GOVERNMENT ARCHITECT NEW SOUTH WALES

PROJECT: Communities Plus, Eden St, Arncliffe
RE: State Design Review Panel – 29th September Review

PROJECT: Communities Plus, Eden St, Arncliffe
RE: State Design Review Panel – 24th November - Fifth Review

Building A

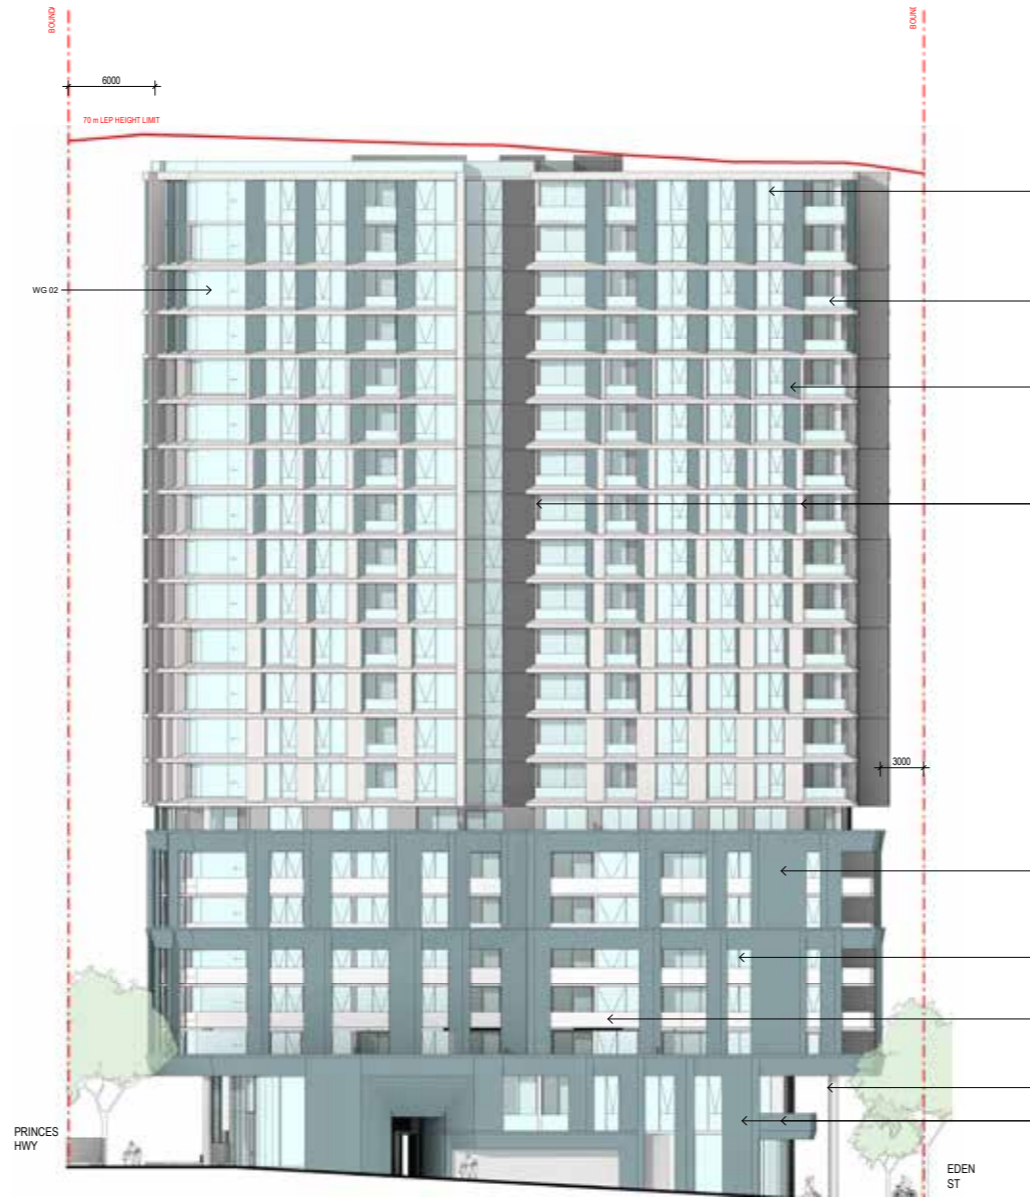
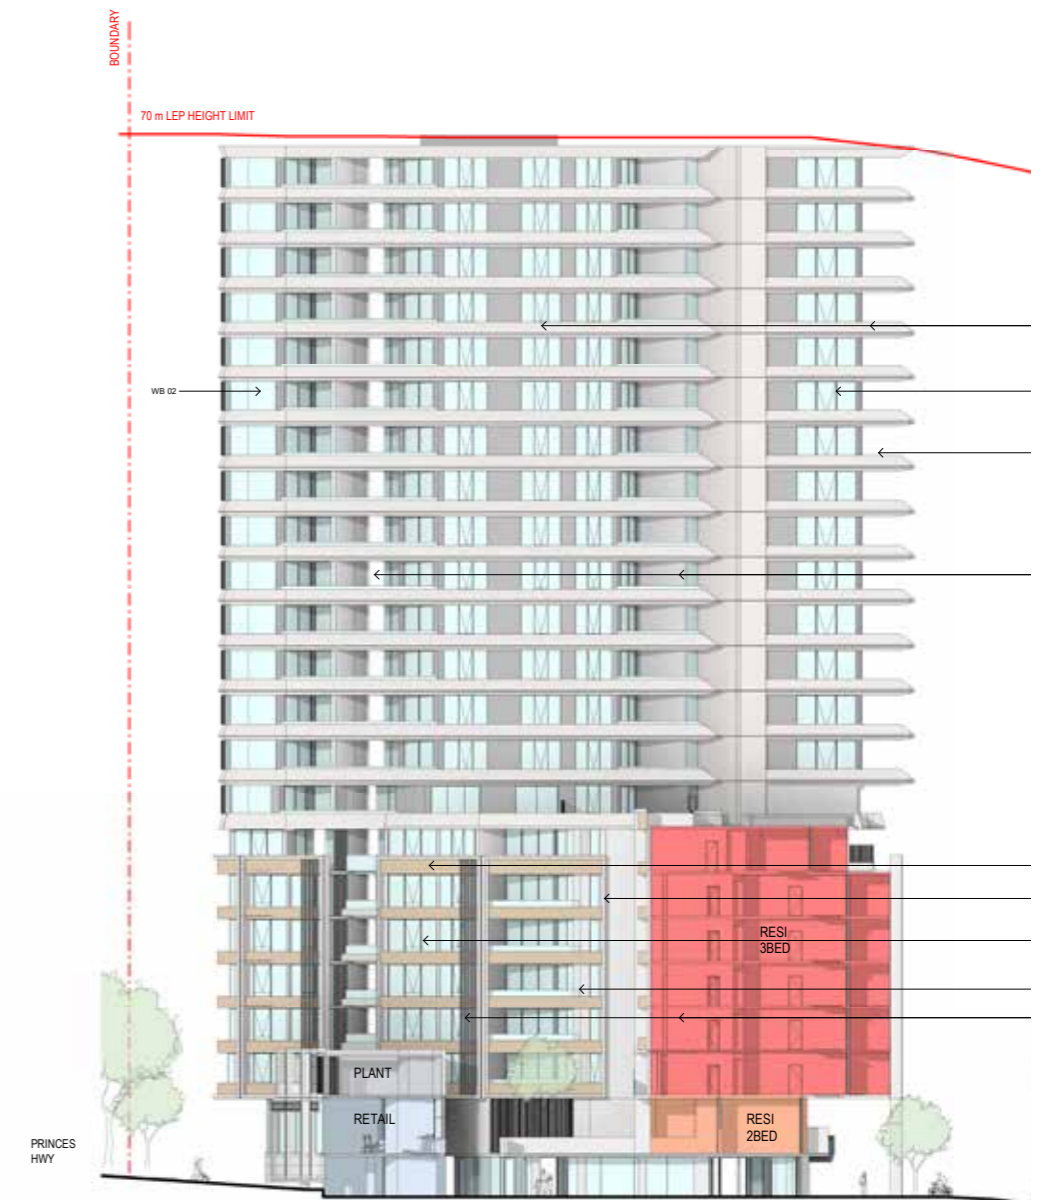
8. Consider similar 'cap' strategies to successfully resolve the tops of the other buildings.

northern view of A

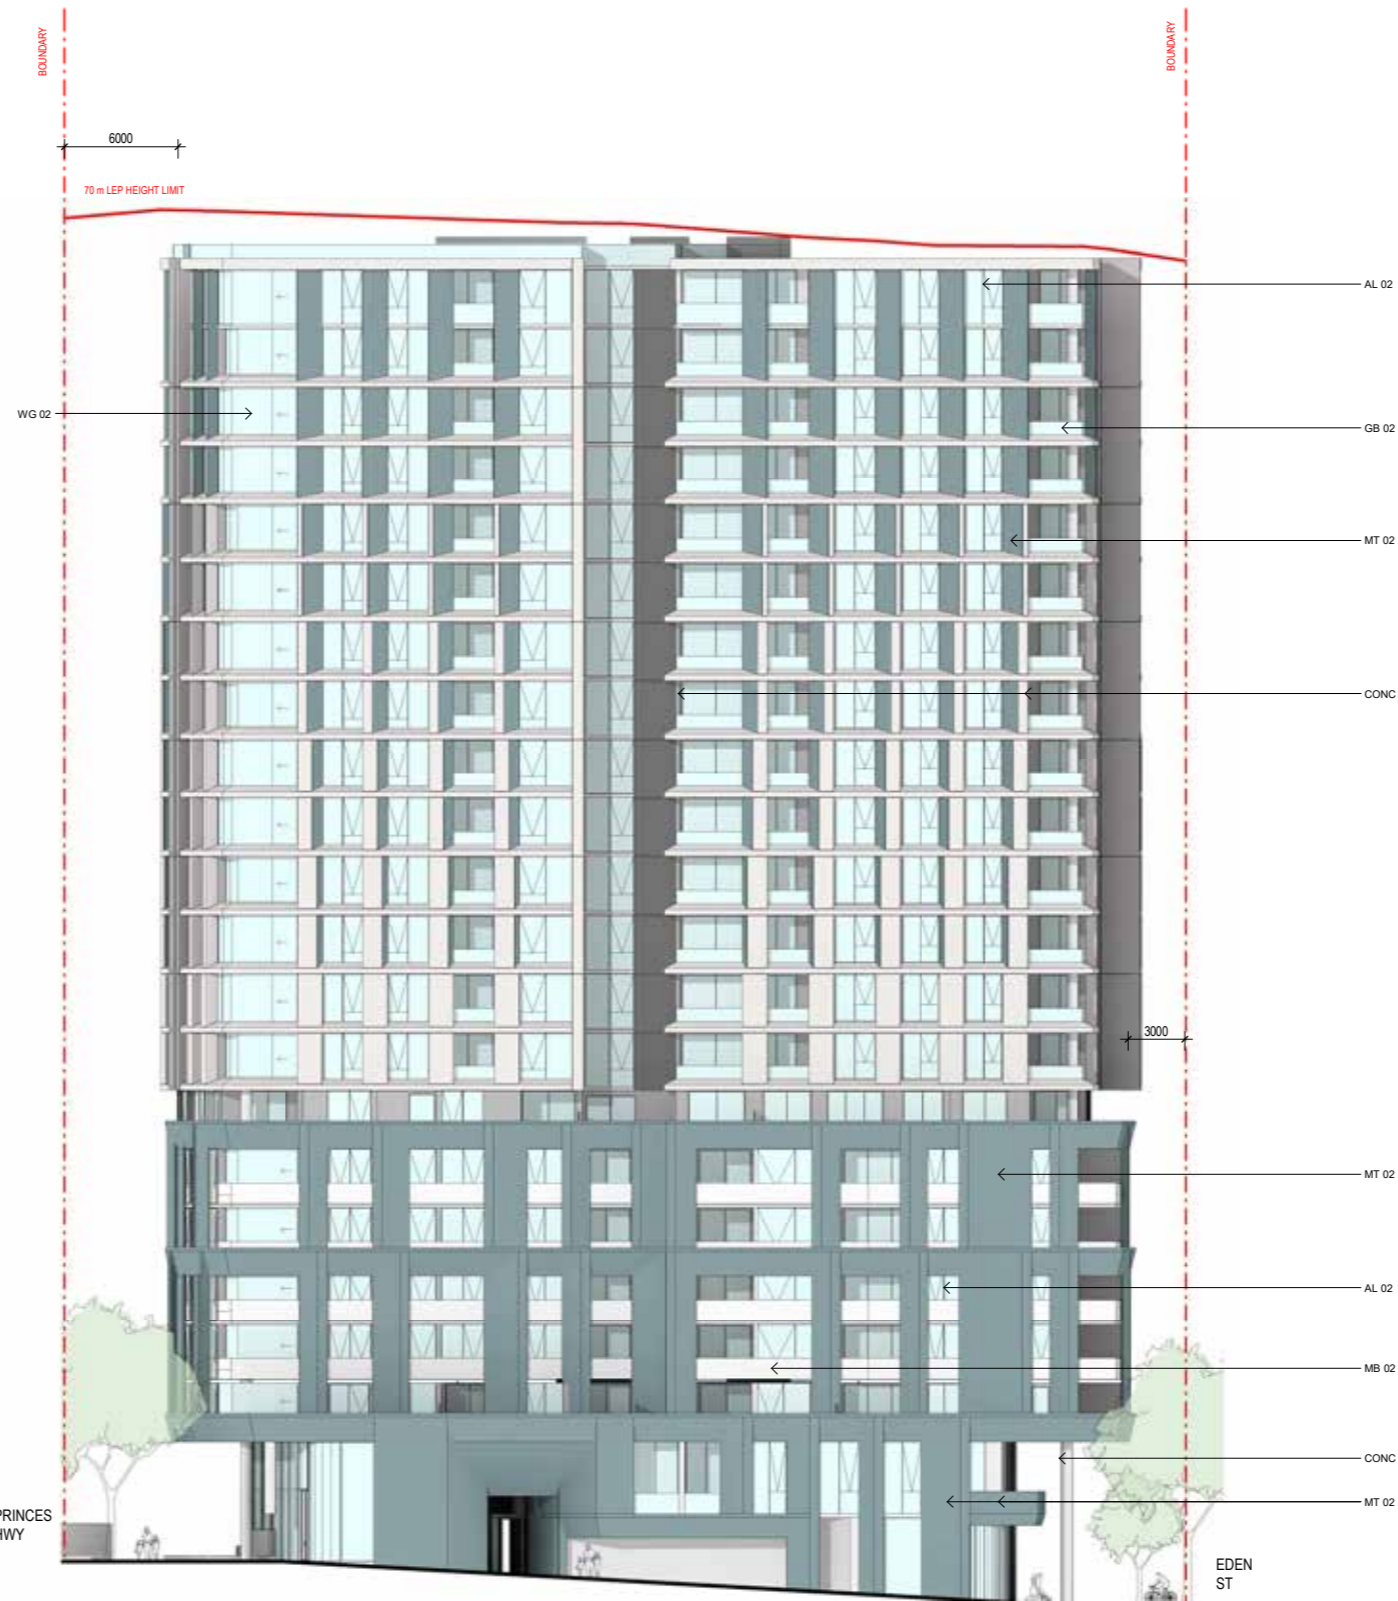
12. The curves in the elevation are unnecessarily complicating this building. Take lessons from building C to simplify the elevations.
13. The Podium needs to be more rectilinear and simplified.
14. The horizontal blades on the tower are too thin and need to be more forceful.
15. Needs more vertical fins on the appropriate facades.
16. Tower needs to read as 4 blocks.
17. Relationship with Eden Street is important and needs more development.

Plotted and checked by	PDS		
Verified	PDS		
Approved	LMC		
Drawing Created (date)	Drawing Created (by) JK, SM, AR, EC, AF		
	20/12/21		
Scale	Project No	Drawing No	Issue
As indicated	180319	DA 3030	D

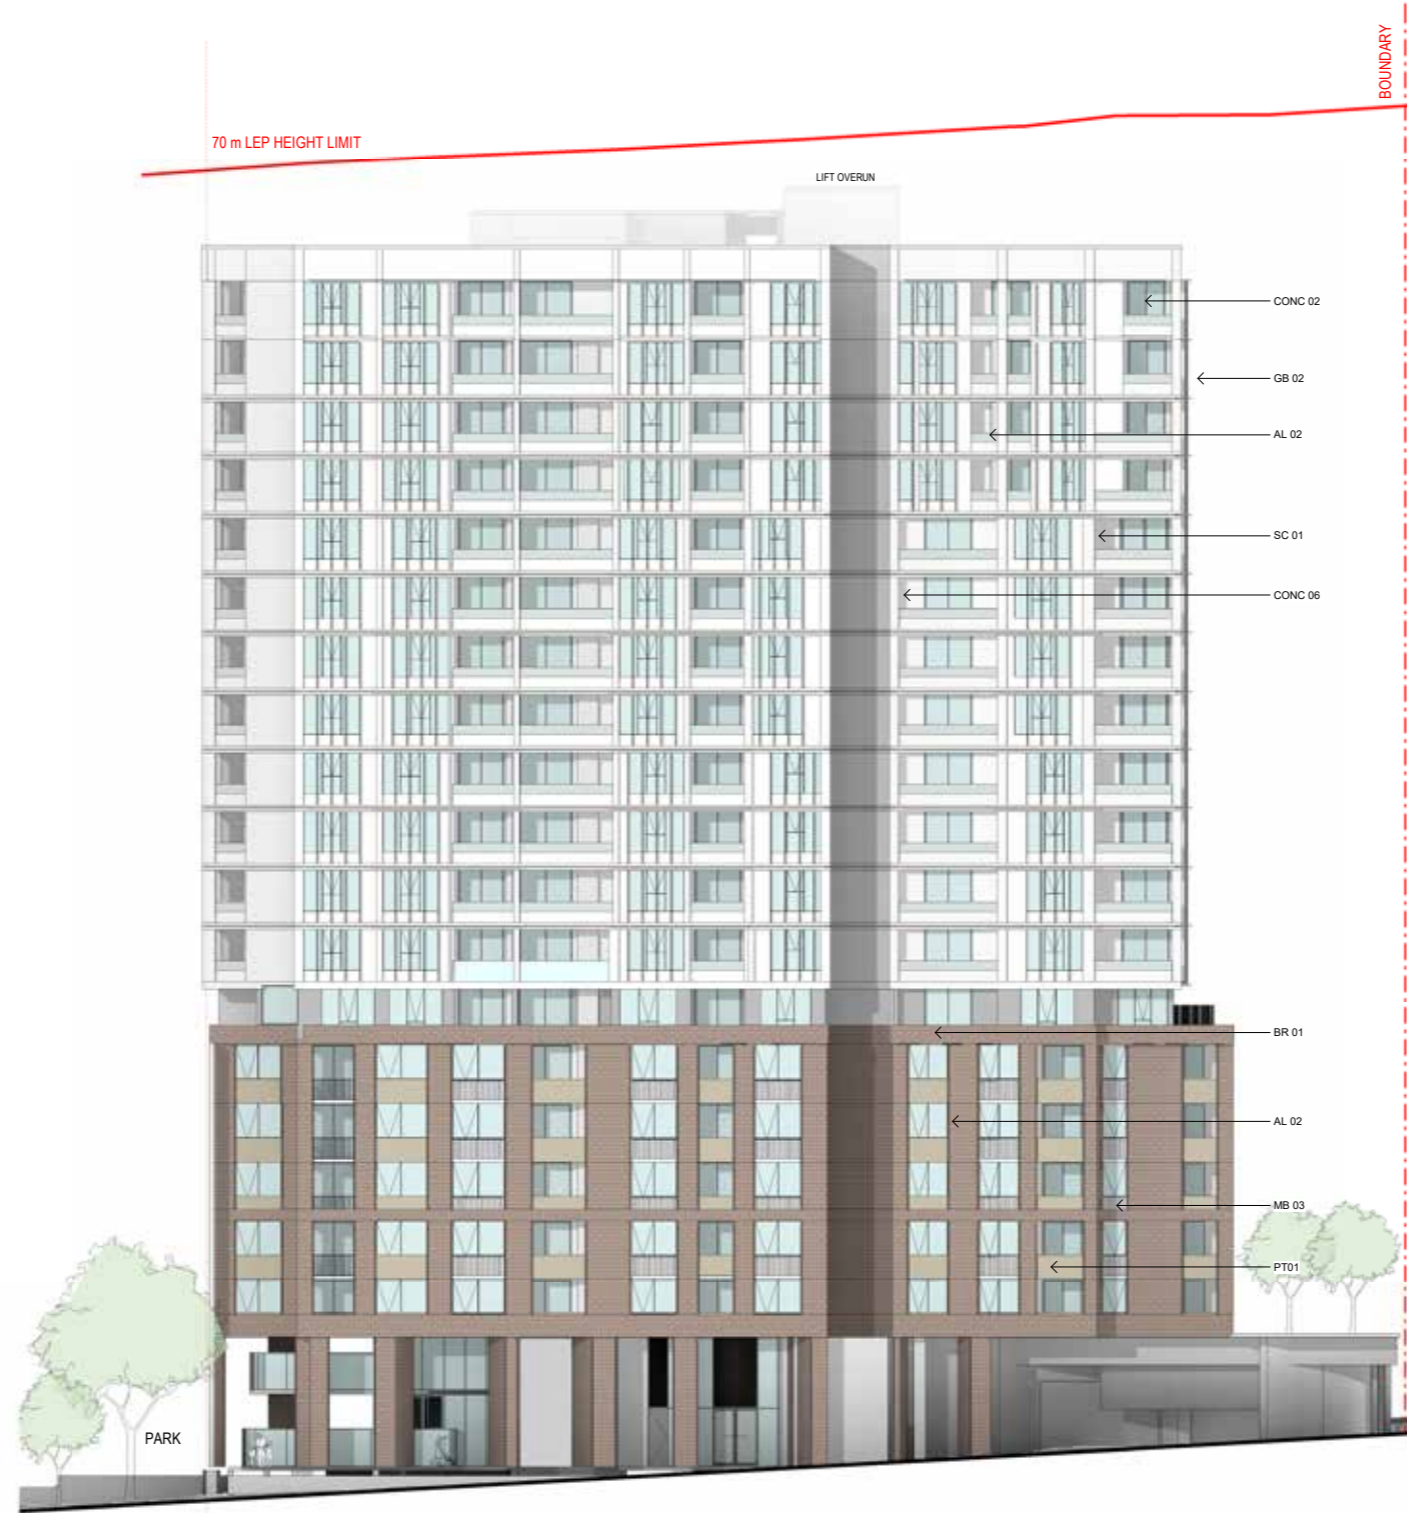
22. Consider making the whole tower the lighter of the current colour treatments and allow sunlight and shade to add richness to the façade. The

23. Support use of corrugated concrete infill panels to contribute to the visual impact of shadow. Look at Candalepas Pelican Street Apartments in Surry Hills for guidance on how to use concrete in a range of treatments, creating a coherent character.
24. Ensure the gold tone on the elevation is bronze and not gold coloured.
25. Simplify the balconies on the podium.

DA SUBMISSION				
Plotted and checked by	PDS	Approved	LMC	Issue
As indicated	180319	DA 3040	D

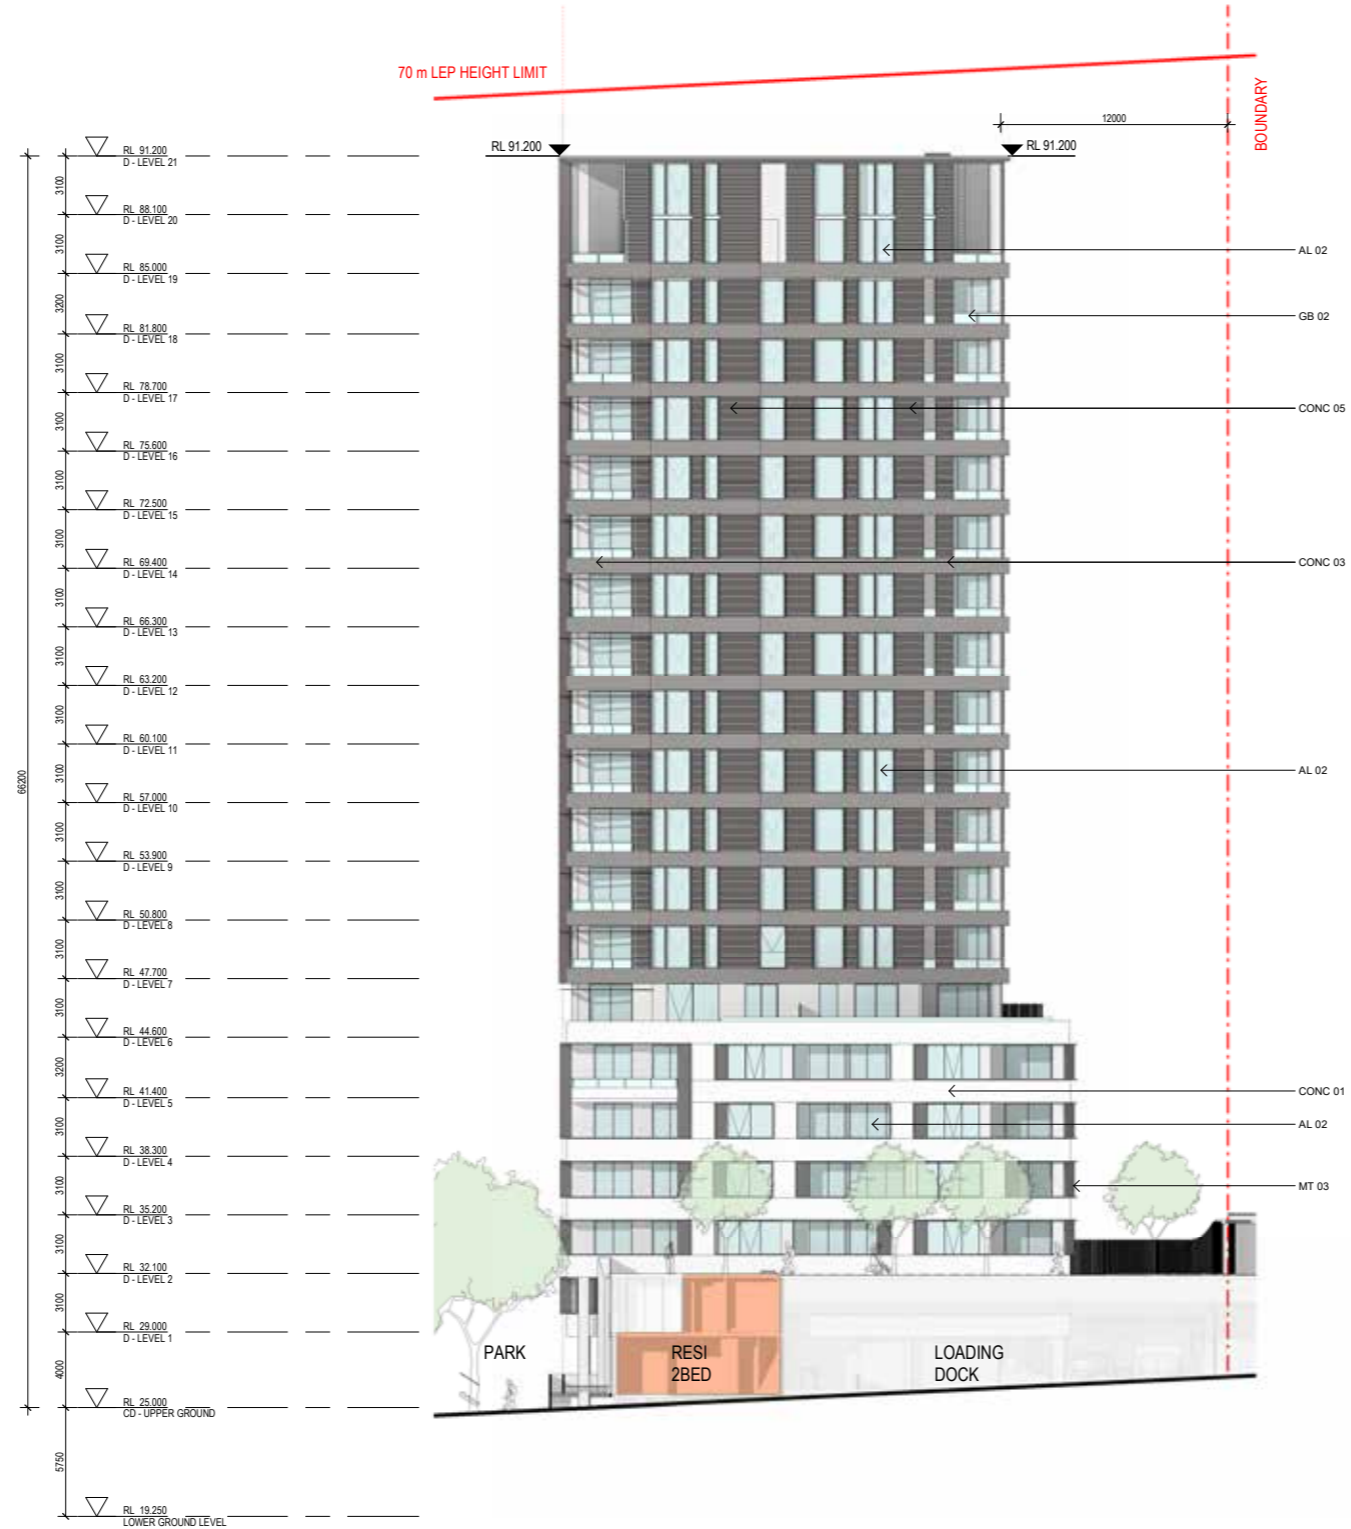
26. The use of infill panels is supported.
27. The contrast between the white brick podium and the darker volumes above is reading as too strong; changing the podium to a mid-grey brick or more natural colours may reduce this contrast and improve the building.
28. Vertical fins (see page 32 of the presentation, lower right image) are too thin and need further development.
29. The vertical cut into the building needs better resolution at its top. The current thickness of the blade walls is not reading strongly enough.
30. The floating roof canopy is starting to provide a stronger 'cap' to this building, but requires further resolution, including possible additional structure.
